From: Jeff Watson
Sent: Tuesday, November 26, 2013 10:33 AM
To: Christine M. Garcia
Cc: Shelley A. McClellan
Subject: BL-13-00024 Taylor

RE: Taylor Boundary Line Adjustment (BL-13-00024),

TO: Jeff Watson, CDS
FROM: Christina Wollman, Planner II *CW*
DATE: November 5, 2013
SUBJECT: Taylor BL-13-00024

60'X60' COMMON ACCESS
& UTILITY EASEMENT TO
SERVE LOTS 1 & 2 AND
FIRE APPARATUS
TURNAROUND.

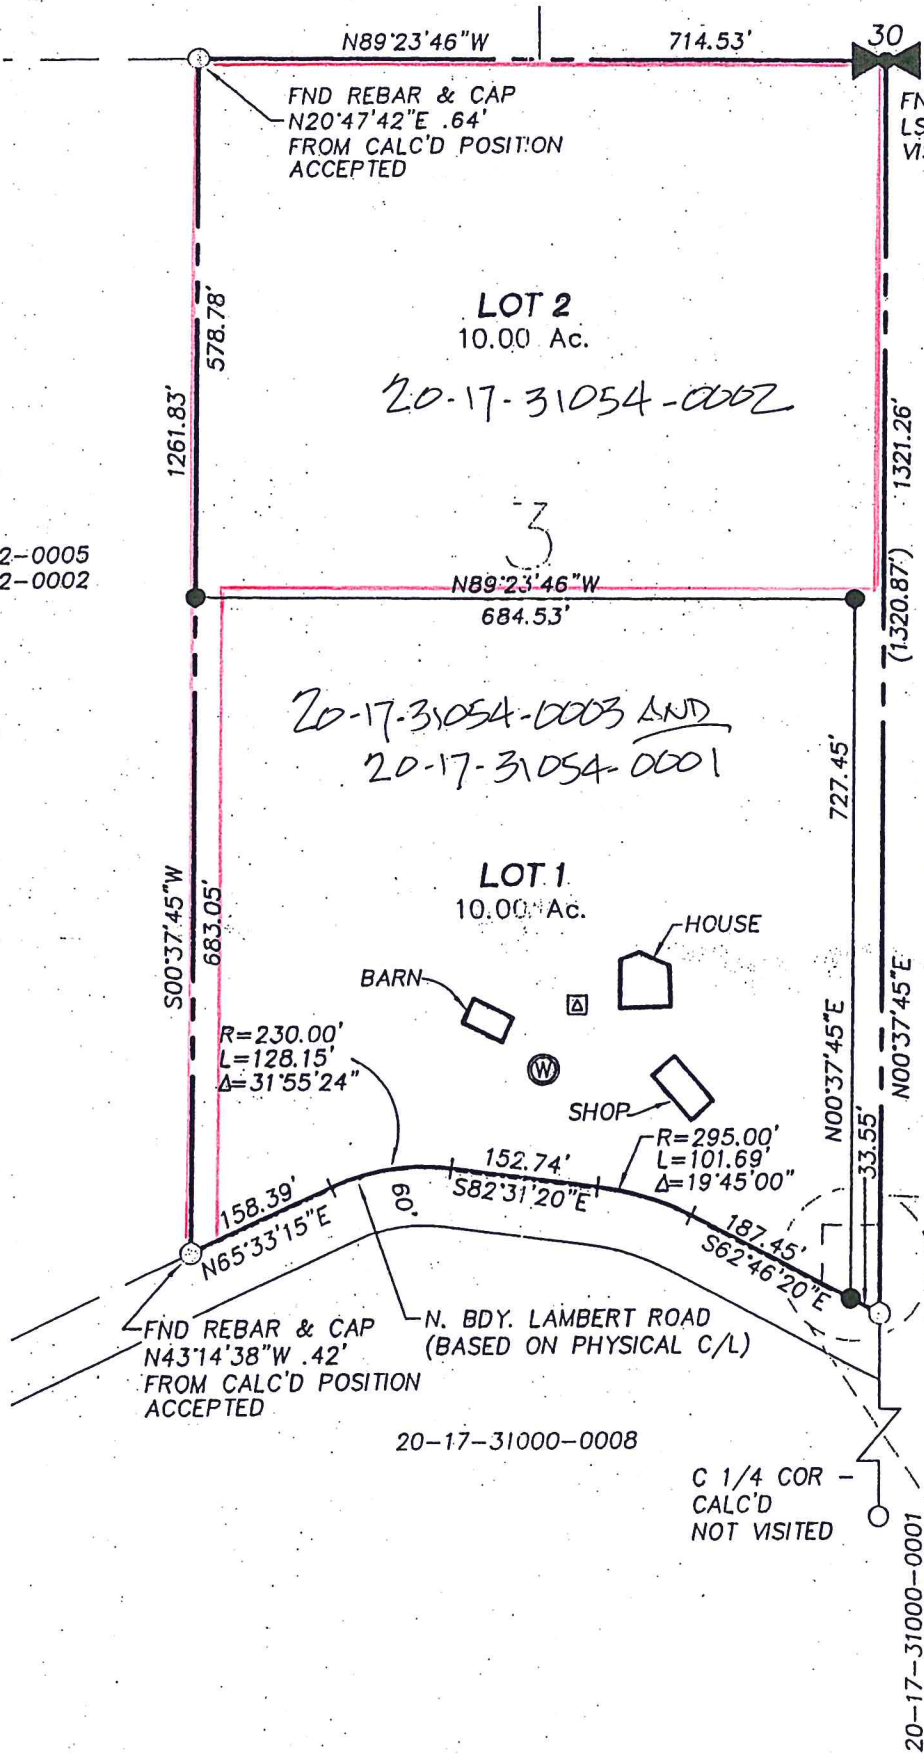
1. A revised legal description that describes the final configuration of the subject property shall be required.
2. The 60' X 60' easement shall be moved to the western property line with the new access to Lot 2.
3. A variance was granted to this property to allow reduced road standards. The road improvements on Lambert Road shall extend to the western property line to the new entrance to Lot 2. An additional turnout may be required. This requirement shall be determined by the Fire Marshal.
